Consultation Response from: KC Environmental Health (Pollution & Noise Control)
2023/92061 - 119, Huddersfield Road, Mirfield, WF14 9DA

Discharge of conditions 6 (right-turn lane), 8 (Construction Management Plan), 10 (electric vehicle charging), 11 (Phase II report), 18 (temporary drainage), 20 (surface water drainage), 22 (hardstanding drainage) and 27 (external lighting) of previous outline permission 2019/92221 for demolition of existing buildings and erection of Class E retail unit, access, car parking, servicing, landscaping and associated works (all matters reserved other than access)

Date Responded:
21st August 2023
Responding Officer:
NH
Responding Ref:
WK/202324877

REV	DATE	DESCRIPTION	DRW	CHK
P01	06.03.23	FOR PLANNING	RD	AG
P02	21.06.23	GENERAL NOTES ADDED	RD	AG

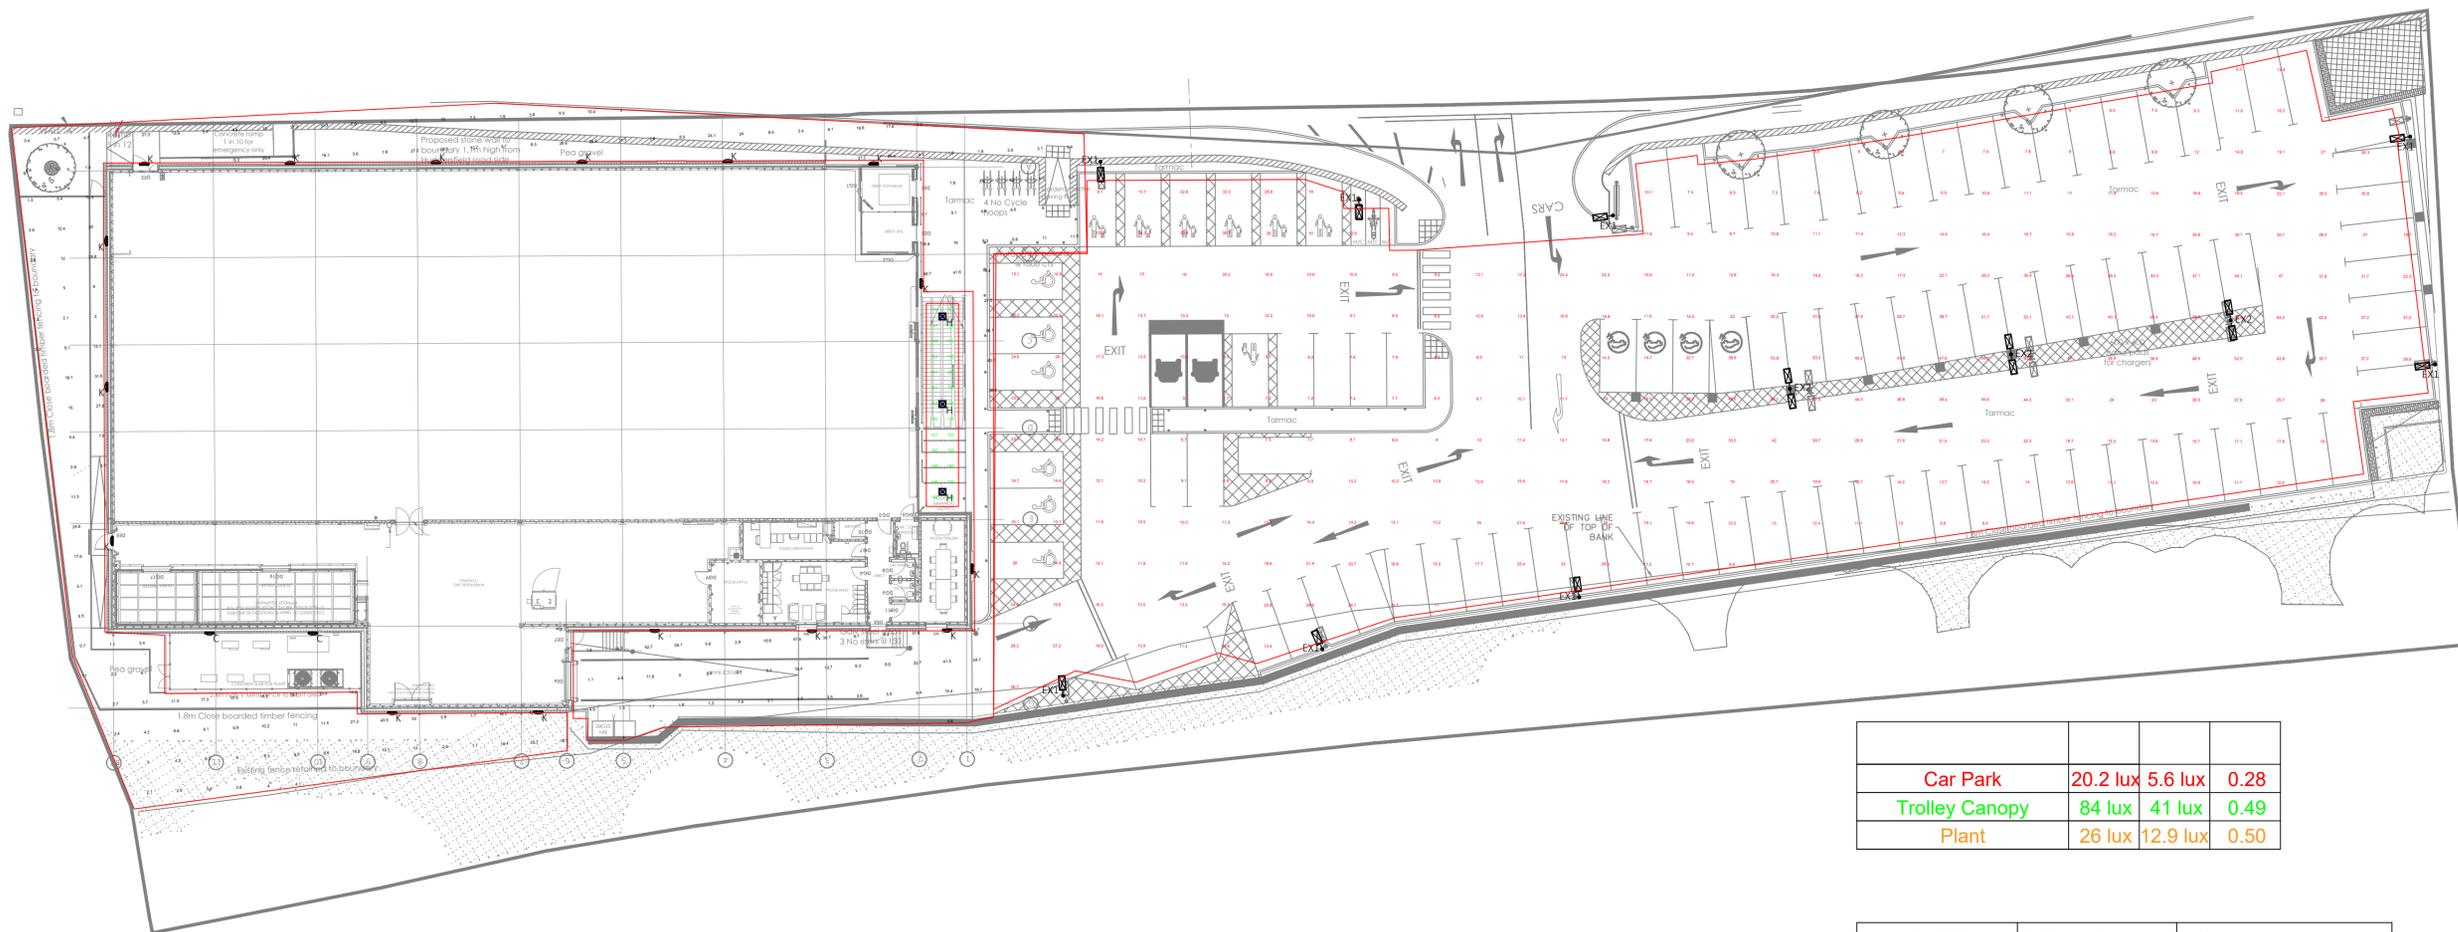
The Electrical Engineering Services External Lighting drawing by Wilson Gray Consulting dated 6th March 2023 (ref: 79-E0000 Revision P02) shows four electric vehicle charging symbols in four parking spaces but it does not provide any further information. We require the applicant to provide more detailed information to support this condition. This must include technical information confirming the type of chargers to be installed.

Considering the short duration of supermarket visits, it may be appropriate for the development if the applicant were to consider incorporating four or more fast or rapid electric vehicle charging points. For these reasons, Condition 10 must remain until further notice.

To fulfil Condition 27, an Electrical Engineering Services External Lighting drawing (ref: 79-E0000 Revision P02) by Wilson Gray Consulting dated March 6, 2023, has been received. We have reviewed the information provided. However, due to incomplete information necessary for a comprehensive lighting scheme as mandated by condition 27, we do not accept the information provided. Therefore, Condition 27 must remain until further notice.

The Electrical Engineering Services External Lighting drawing by Wilson Gray Consulting dated 6th March 2023 (ref: 79-E0000 Revision P02) is accepted but does not provide the necessary information to fully satisfy the requirements of the Condition. Therefore, Condition 10 must remain until further notice.

Due to incomplete information necessary for a comprehensive lighting scheme as mandated by condition 27, we do not accept the information provided. Therefore, Condition 27 must remain until further notice.
